From: Simon Davis
Sent: 10 December 2021 13:42
To: 'Sparkes, Jessica' [REDACTED]
Cc: Rose, Andy [REDACTED]
Subject: RE: PSI_3560_02 Drove Lane off site works, Yapton

I'm pleased that the slightly amended location is acceptable, it's not far from the position shown on the plan appended at Appendix 6. That plan (pdf page 83) confirms that the drawing is '*to be treated as indicative and is for discussion purposes only*' and the associated definitions (pdf page 8) similarly confirms that the locations is '*shown indicatively on drawing number 14-111/305 appended to this Agreement at Appendix 6*'.

From: Andrew Muthusami [REDACTED]
Sent: 07 December 2021 17:05
To: Lee Moses [REDACTED] William Johnson [REDACTED] Andrew Howick [REDACTED]
Cc: Simon Marks [REDACTED] Rose, Andy [REDACTED]
Subject: RE: PSI_3560_02 Drove Lane off site works, Yapton

Scale	Date	Designed
1:500 @A2	MAR 2018	TDM
Drawn	Checked	Approved
TDM	TDM	RH
Job No	Drawing No	Rev
14-111	14-111/305	-

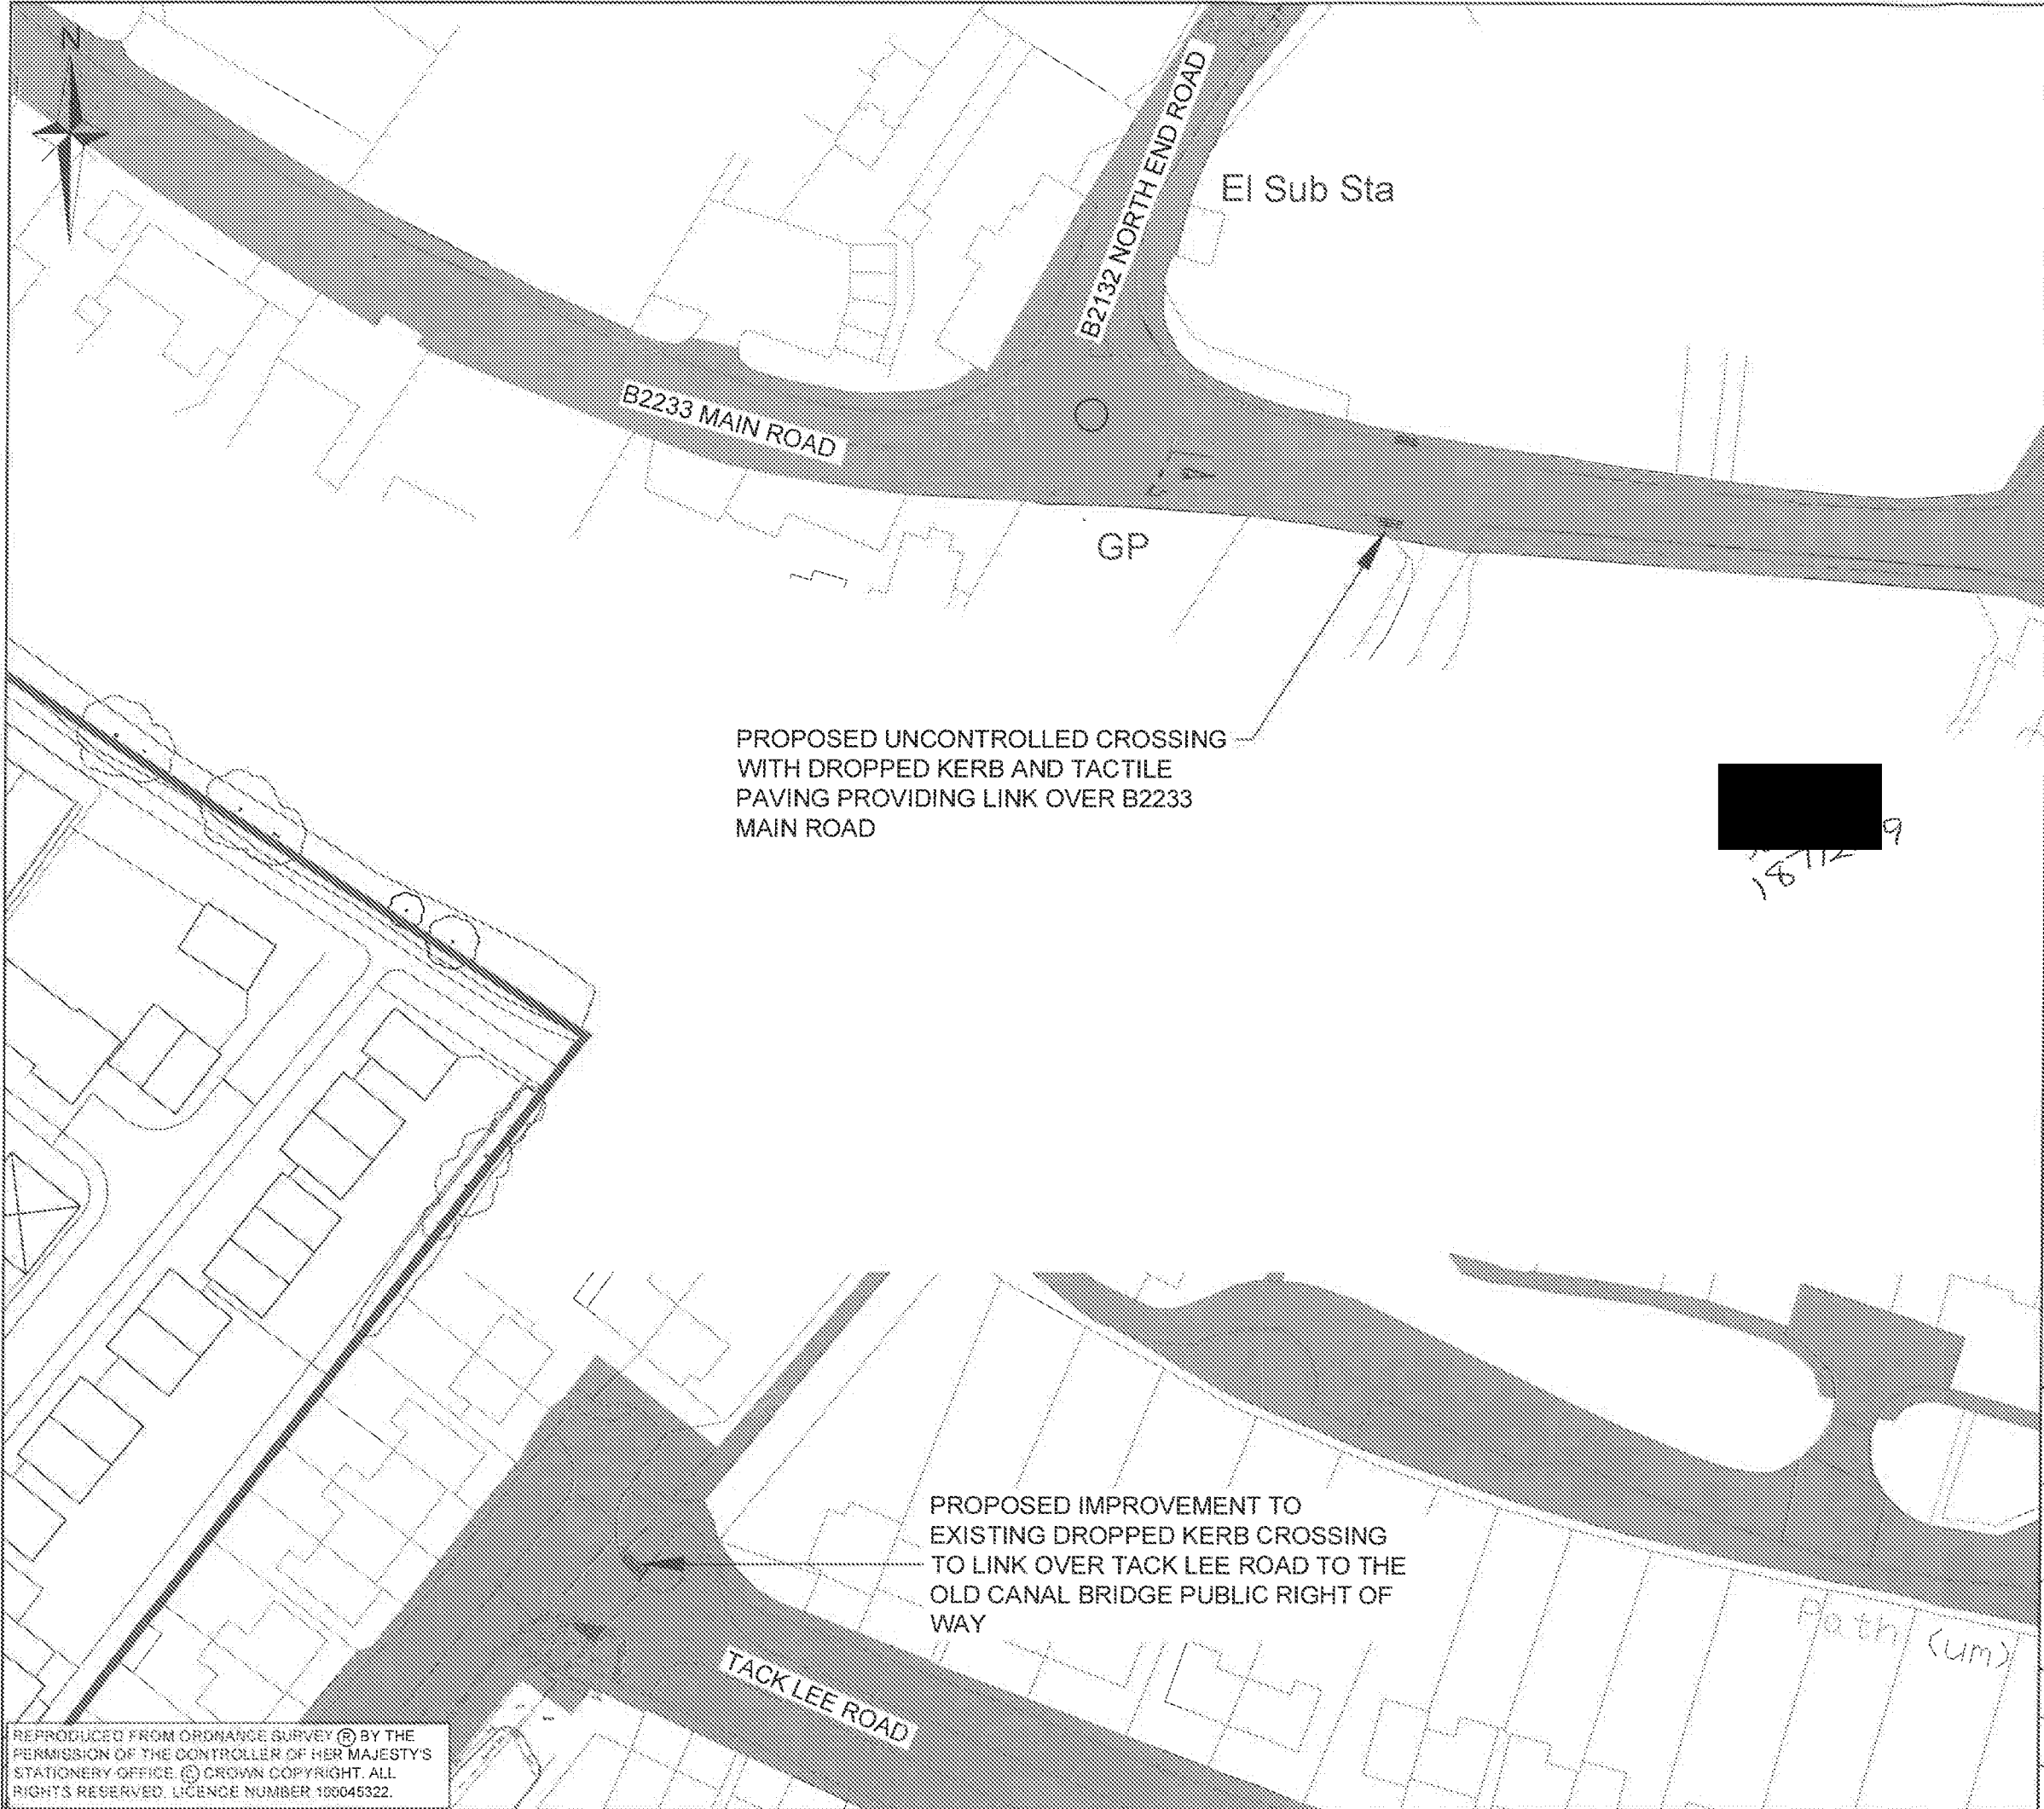
I have no concerns with the change in the position of the crossing point being as though it will only be a couple of metres east of the approved position. However, the current position is shown on a plan which forms part of the s106 legal agreement. In my view, to make this change would require a variation to the agreed s106. This may or may not require the submission of a formal application to vary the s106. It may be easier to determine whether the existing crossing point can be achieved without affecting the drainage but in any case, I suggest that you discuss with BDW.

We have put a query out to ACO with regards to installing a dropped kerb over the channel without cutting the drain off and are awaiting their response. Following discussion with BDW we were wondering if it would be possible to locate the crossing point on the other side of the church access road as per the mark up below?

This would result in some of the verge being required to be changed to footway to accommodate the crossing and link to the existing footway. Is this an option that can be explored in lieu of a response from ACO? BDW have confirmed that the crossing point indicated through the S106 Planning Consent is indicative so there would not be an issue with it moving from a planning point of view.

I have reviewed the s106 and drawing again and I agree that both refer to the plan as indicative. I note that the plan itself also states that the proposals may need to be reconsidered based upon information which subsequently becomes available. Therefore, I agree that no Deed of Variation is required.

On that basis and given that the crossing was only ever shown indicatively, there should be no requirement for a DoV because there is nothing to vary.
